Demolition of the existing Foreshore office & decommissioning of existing underground toilets. New purpose built unisex toilet block including urinals, baby changing facilities & accessible WC, plus a separate beach office with public information point & first aid facilities. All located on the existing seafront promenade.

Promenade Opposite Walton Avenue The Esplanade Bognor Regis

Thank you for your internet representation made on 5th January 2018 which has been recorded as '**an objection**' with the comments as follows:

drain detail

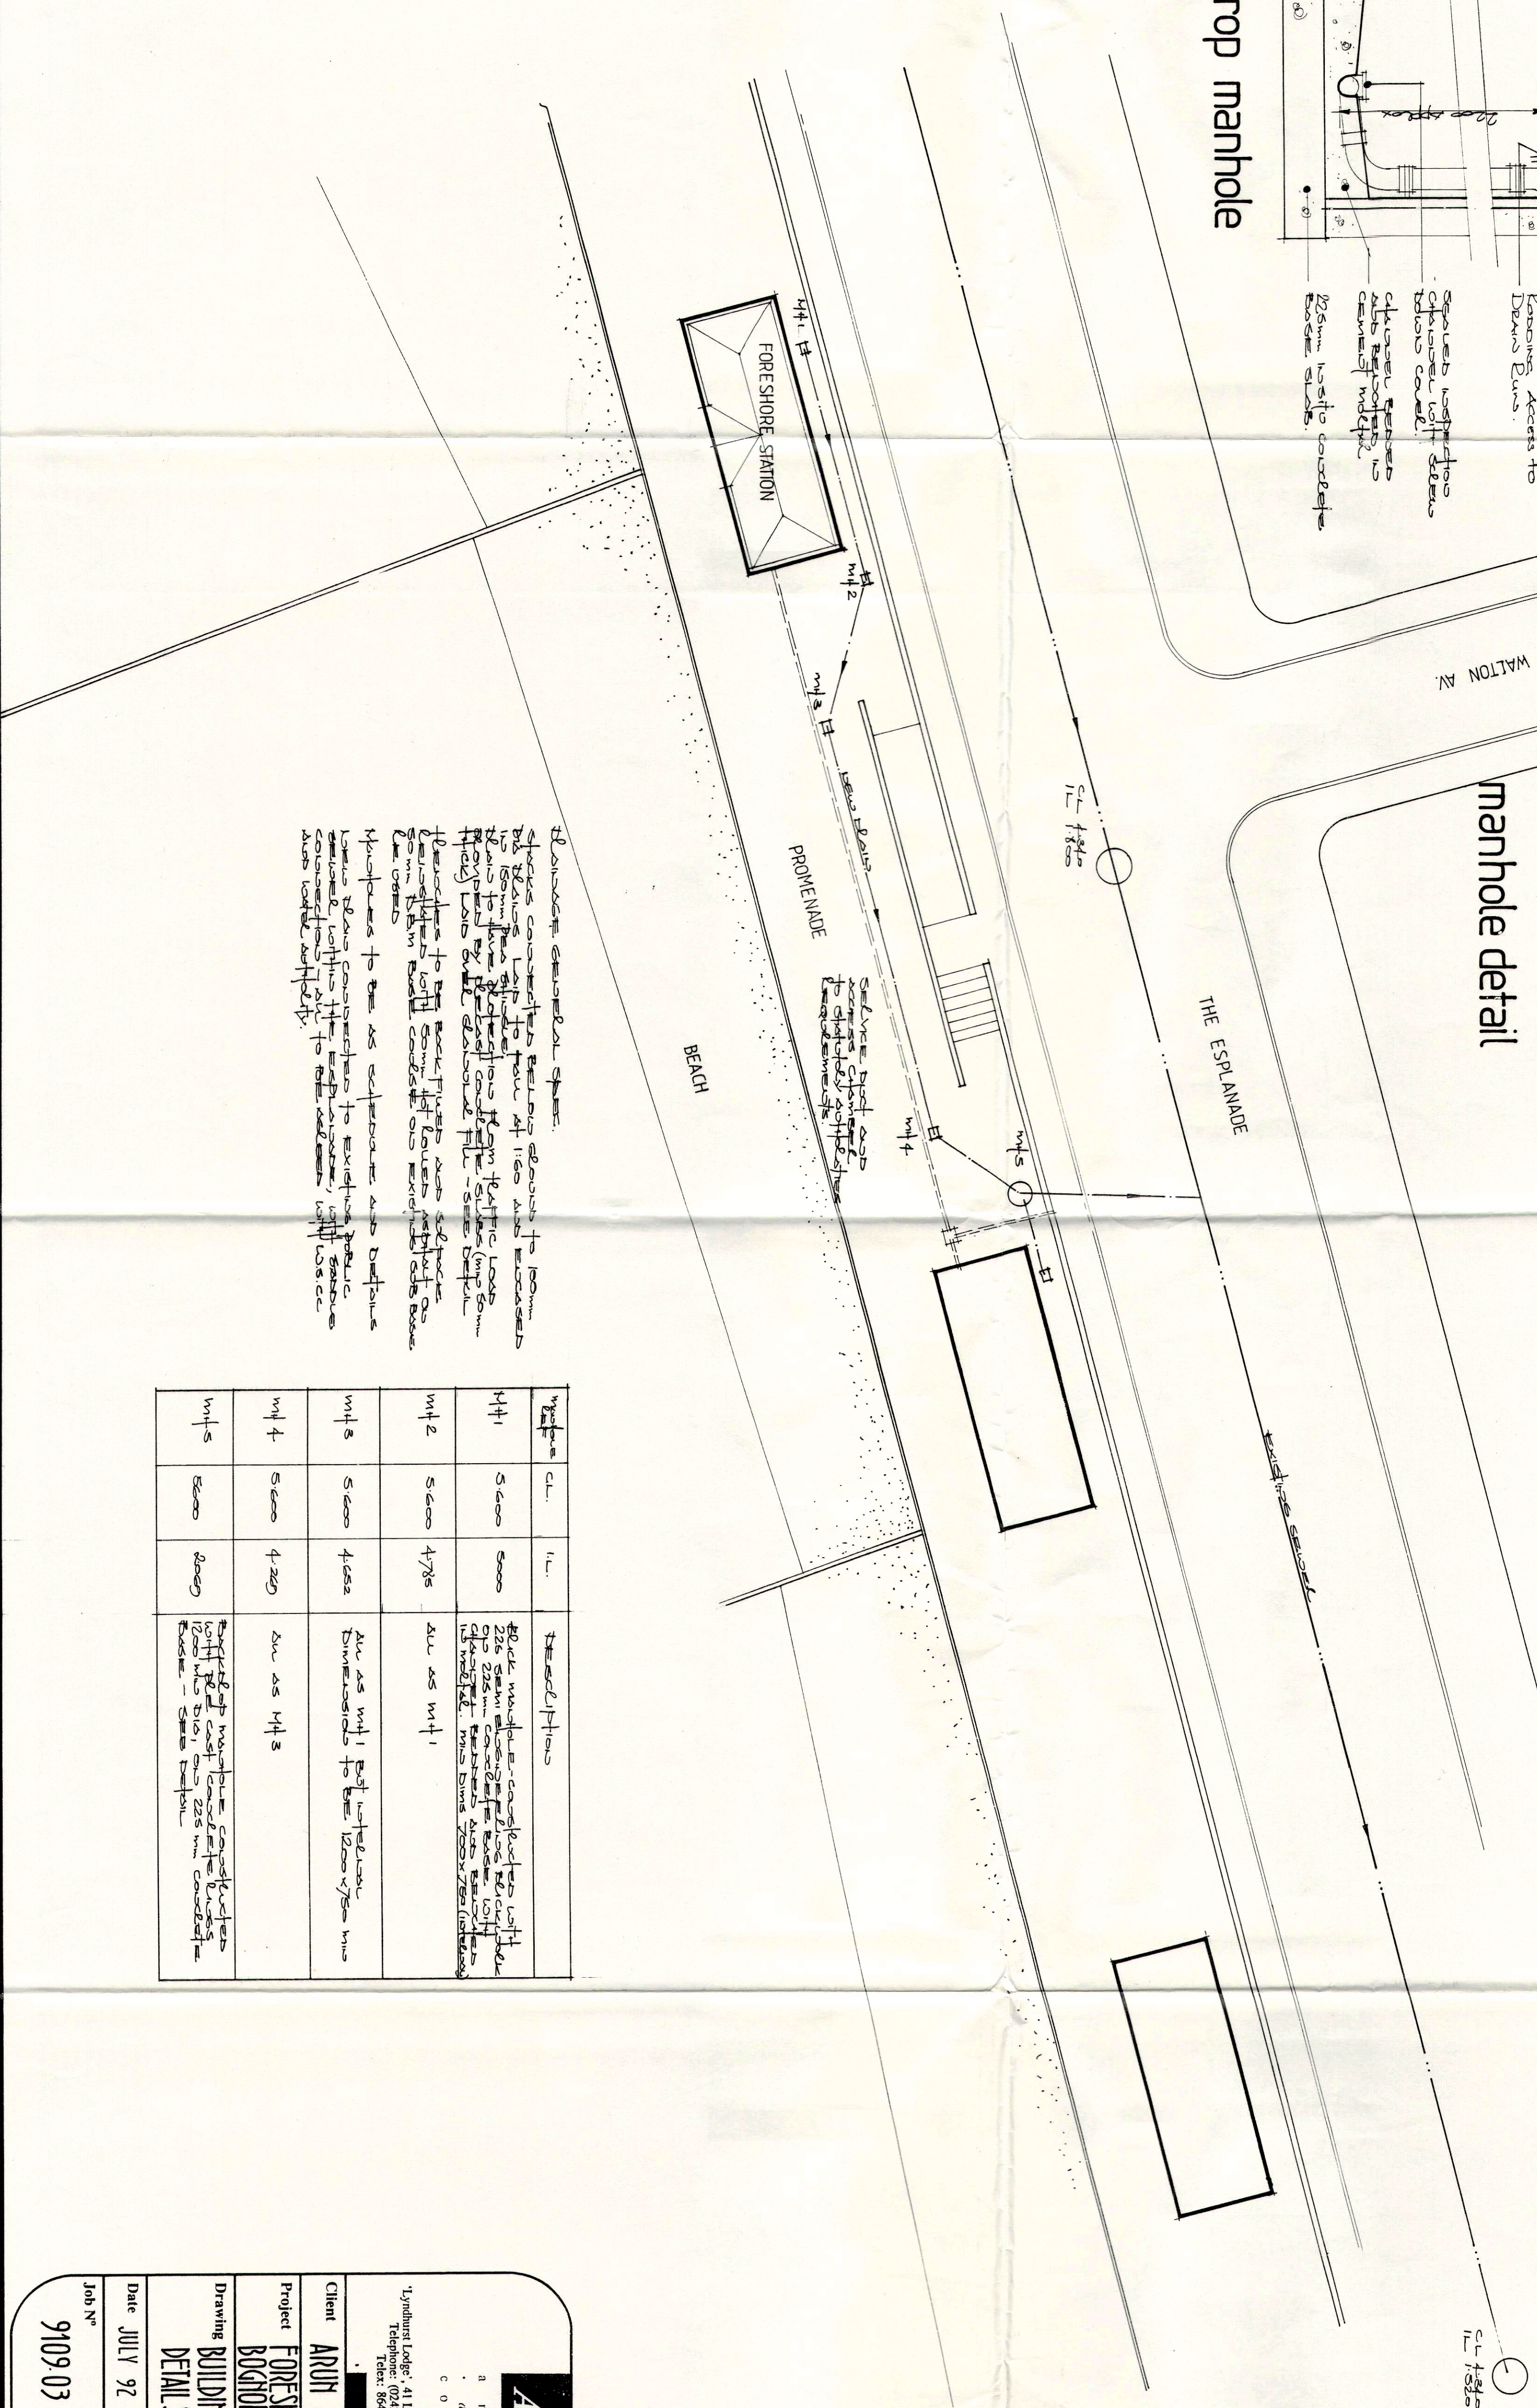
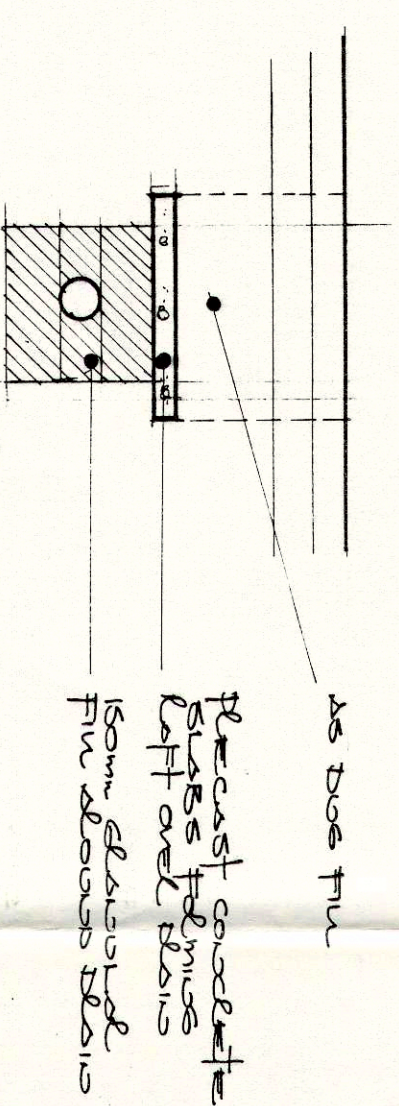
Directing the New Proposed toilets away from the main sewer would not be viable, in contrast the sewer does run EAST from Gloucester Road to the WEST which in turn allows for a more positive site at the car park Gloucester Road where many seaside activities take place within a safer location for the young and not so young.

DRAWING
Proposed Elevations North-South

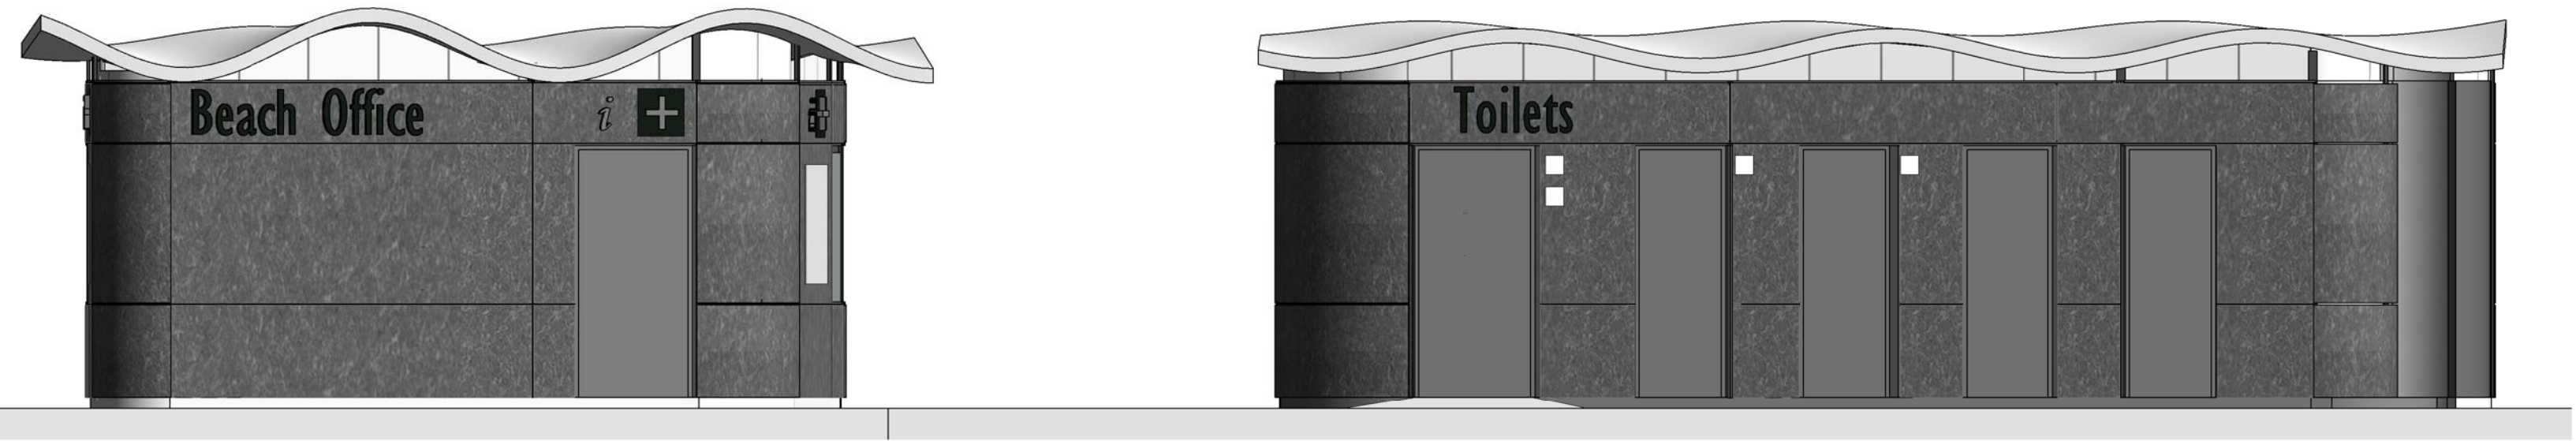
Signage The current proposed signage is NOT in keeping with the overall concept of the Toilet Block with 1 meter high and 3 meters in length it is obscene to the eye and should be restricted to EAST WEST and SOUTH facia ONLY, North facing signage is NOT in keeping with all OTHER signs along The Esplanade.
